Application by North Falls Offshore Wind Farm Ltd for North Falls Offshore Wind Farm**The Examining Authority's written questions and requests for information (ExQ3)****Issued on 1 July 2025**

Responses are due by Deadline 7: 15 July 2025

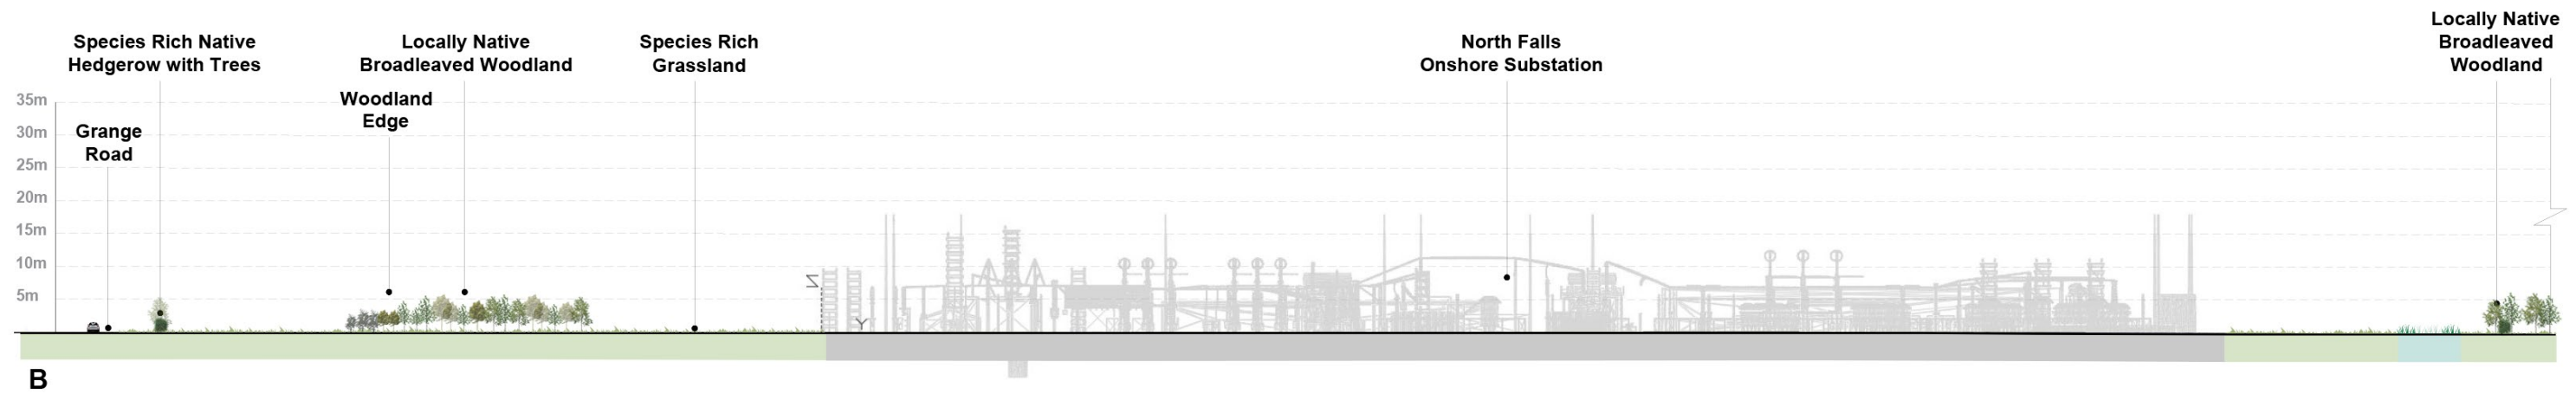
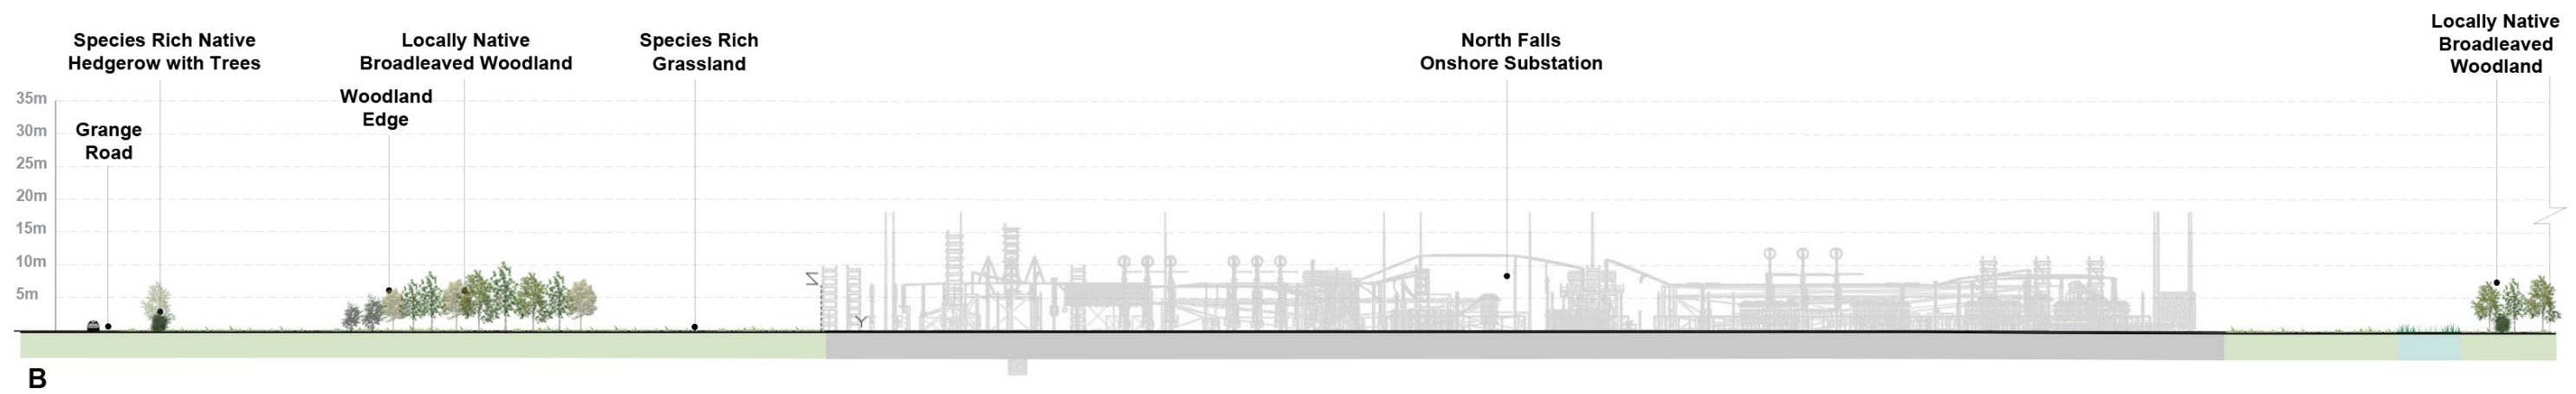
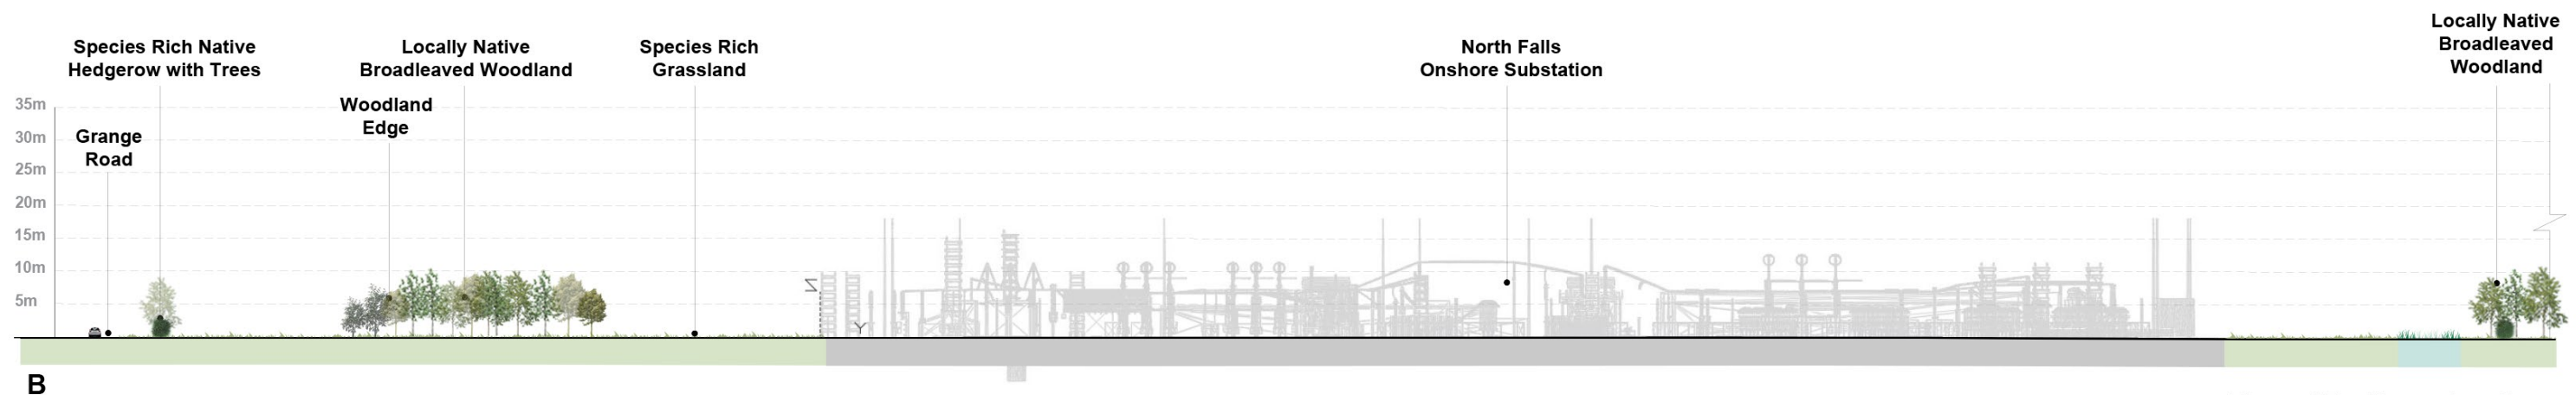
13. Human Health		
		No ExA third questions.
14. Landscape and Visual		
Q14.0.1	Applicant	<p>Visual Mitigation at Substation</p> <p>The ExA notes the update to 9.30 Indicative Planting cross-sections at the onshore substation (Rev 2) [REP5-035] at Deadline 5. This confirms that planting would not be orchard planting but a series of woodland belts.</p> <ul style="list-style-type: none"> i) Please can the Applicant elaborate, setting out timescales to maturity and at what point the screening will have taken full effect. ii) With regard to the Written Landscape Scheme, could the OLEMS clarify the details of trees, woodland and hedgerows, finished ground levels and bunding, and plant details including, where possible plant schedule will also be provided as drawings to illustrate the written details. Could boundary treatments also be included on the drawings for clarity.
Q14.0.2	Applicant	<p>Screening at Substation: VEOWF</p> <p>REP4-038 (10.20.8 Technical Note - Screen planting options for Land Plot 17-024) submitted to the VEOWF Examination (see [REP4-038]) provides indicative cross sections to illustrate the potential mix of screening planting, as well as how this might mature over 5, 10 and 20 years. The planted woodland areas would screen the onshore substation, and provide a landscape feature. Please can the Applicant provide commentary on principle differences between the VEOWF proposals and those of NFOWF, and what further steps can be taken to align them.</p>
